CITY OF PORTLAND, MAINE
PLANNING BOARD

July 29, 2016

Project Name: "Station 415" Subdivision and Change of Use: Co-Working Office Unit
and three (3) Apartments

Project ID: #2016-152
Address: 415 Cumberland Avenue CBL: 036 G033001
Applicant: Andrew Kraus, M & A Lowcountry Investments, LLC
Planner: Jean Fraser

FOREST AVENUE ELEVATION  
SCALE: 1/8" = 1'-0"

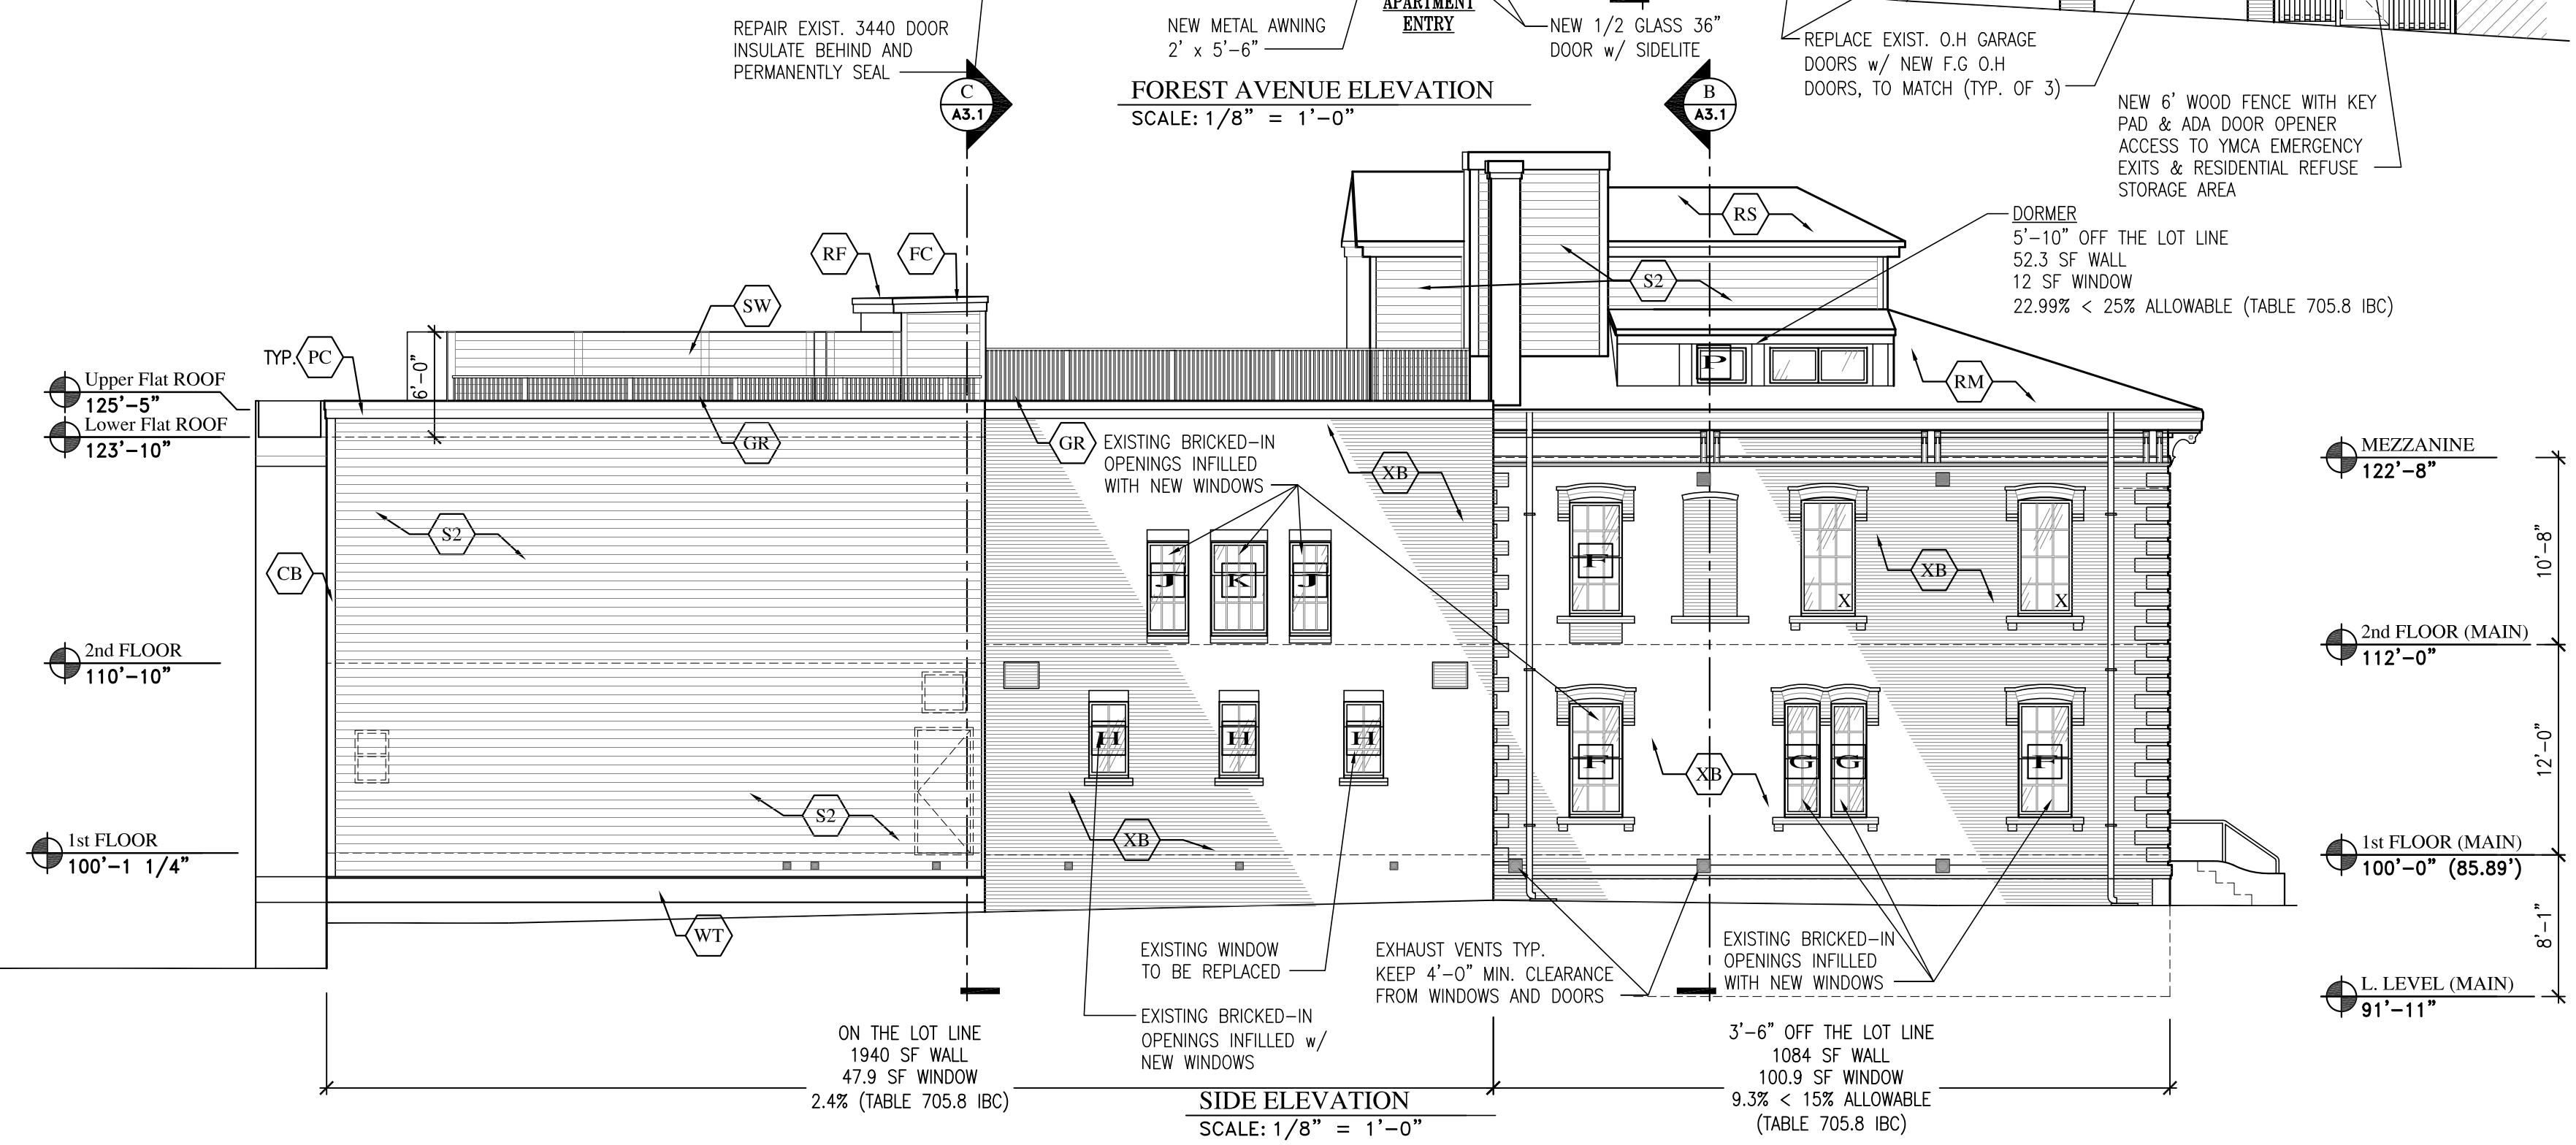
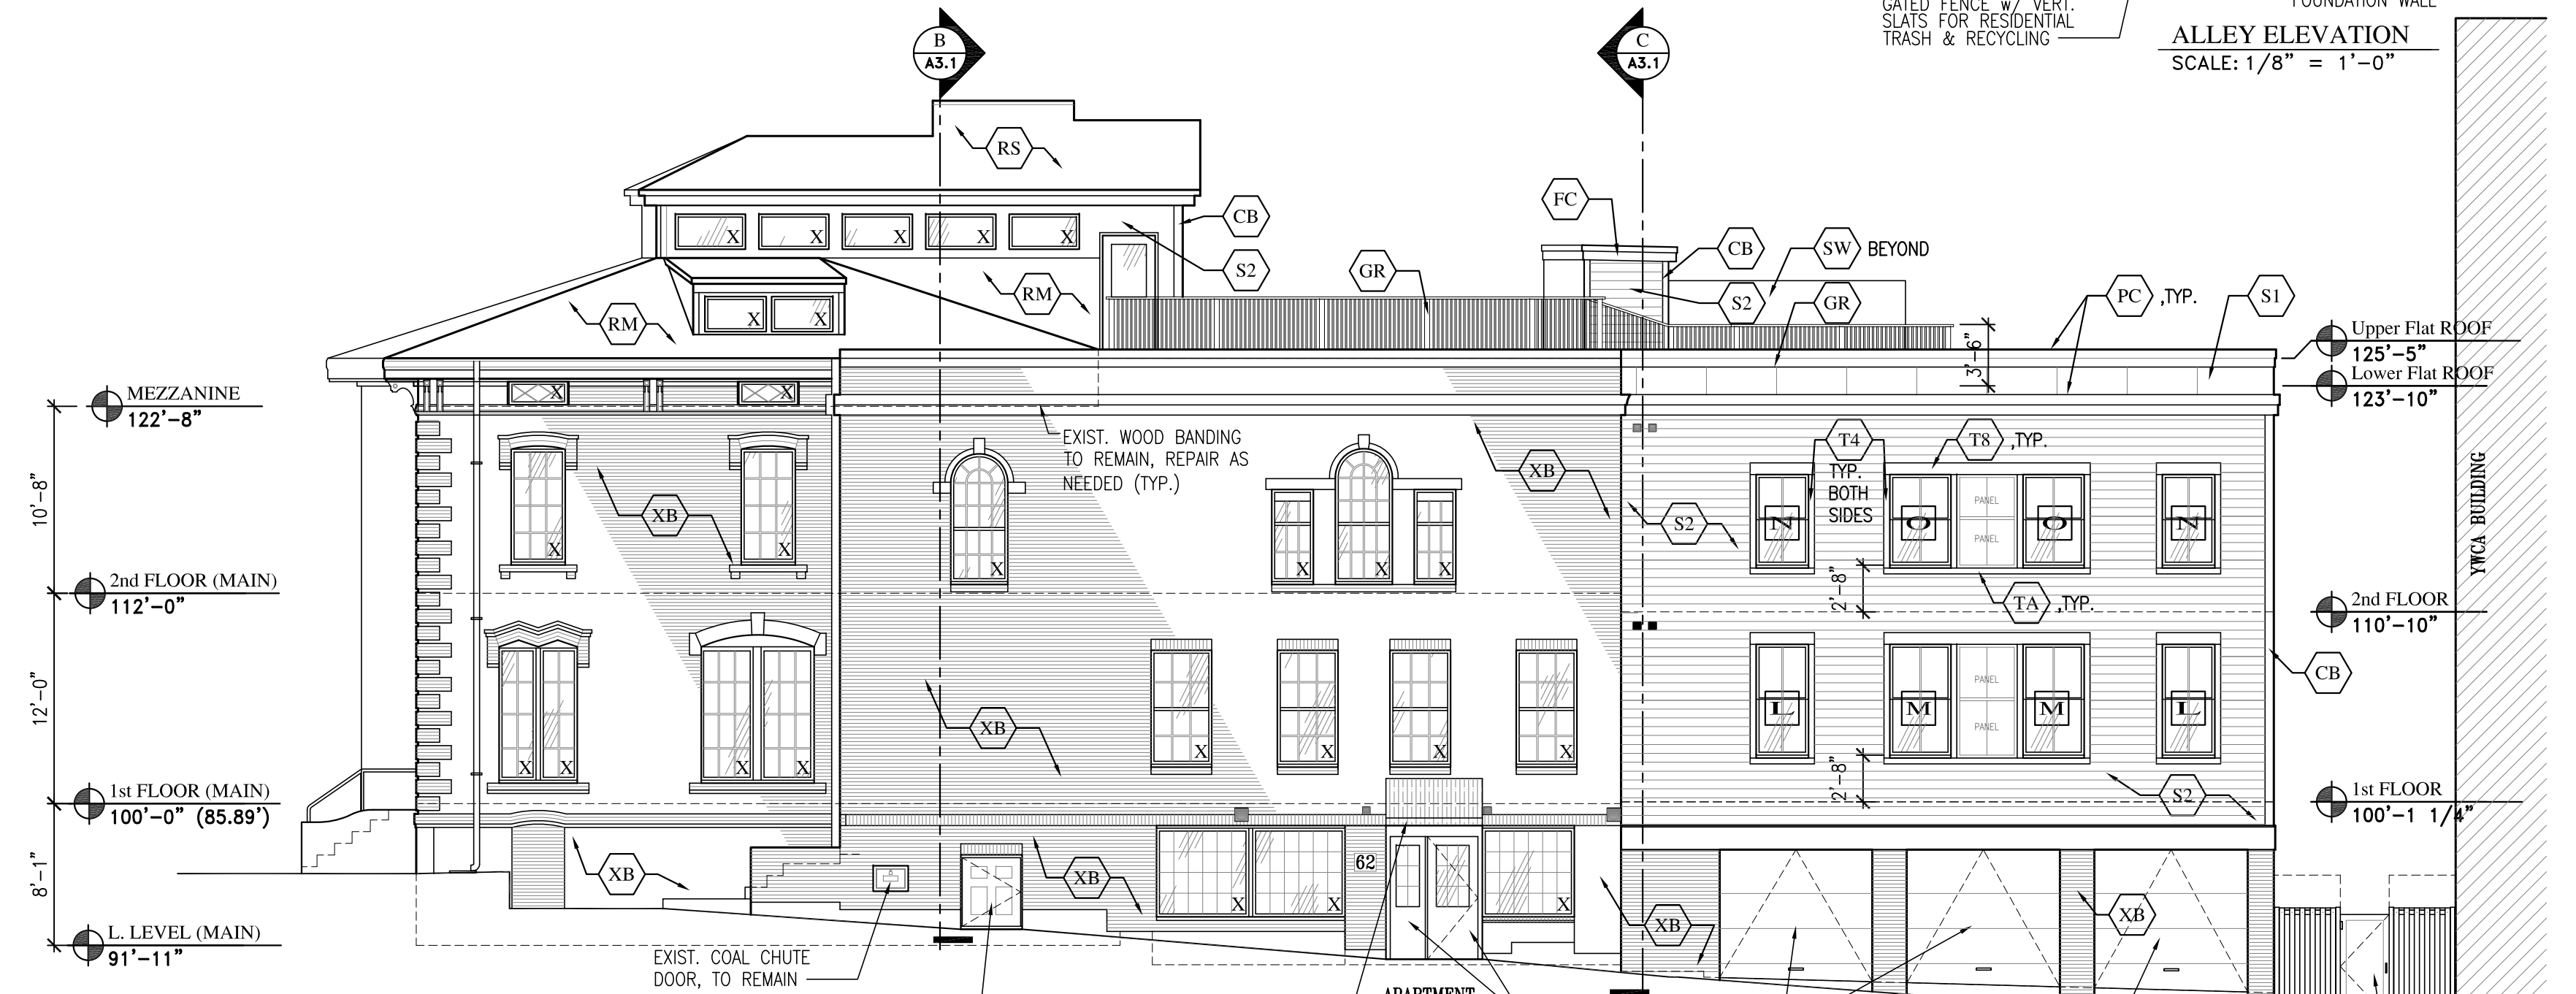
- D) The route to the outside bike racks located within the applicant's property; and
 - E) Improved screening of the trash storage area.
- ii. That the applicant address the comments of the Historic Preservation Manager dated 7.21.2016 in respect of the tone of proposed new cladding on the Forest Avenue elevation, prior to the issuance of a building permit; and

The 7/20 design appears to be responsive to most of the previous review comments provided by this office, as well as comments of the Planning Board and staff. The one outstanding issue that might warrant further consideration is the replacement exterior cladding proposed for the rear addition facing Forest Avenue. Although the material itself is acceptable and its running bond pattern relates to the running bond brick of the abutting historic structure, staff suggests that the scale of the individual cement panels be reduced somewhat. A reduction in scale of individual modules would likely result in a more subtle and intentional relationship between the finer grain brick of the historic structure and the contemporary exterior of the addition. Also, staff suggests that the tone of the addition be darker than what is presented to provide a more recessive appearance.

PARTIAL FIRST FLOOR PLAN - LOT 2 & 3  
SCALE: 1" = 10'

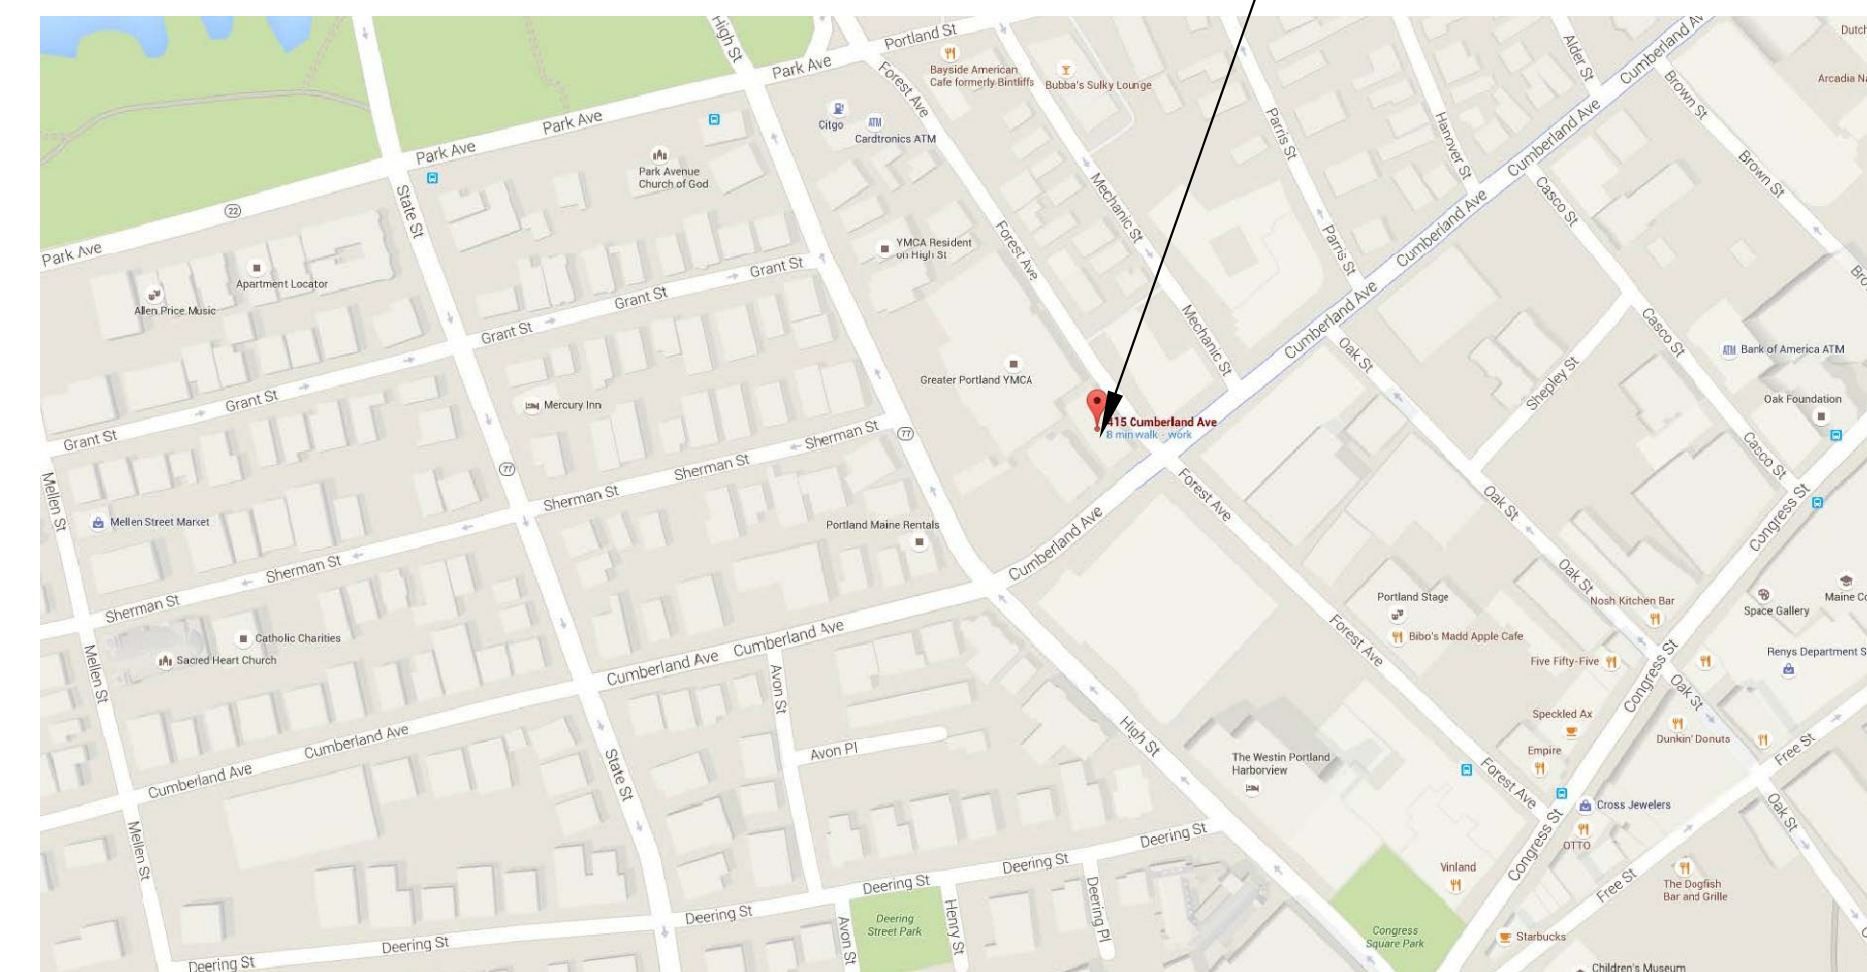
- i.* That the Subdivision Plat shall be finalized to the satisfaction of the Planning Authority, Corporation Counsel, and Department of Public Works, and include clarification of easement and other information along with relevant notes and conditions prior to submission for Planning Board signature; and
- ii.* That in the event the property is converted to a condominium, that the recorded condominium documents shall be copied to the Planning Authority.
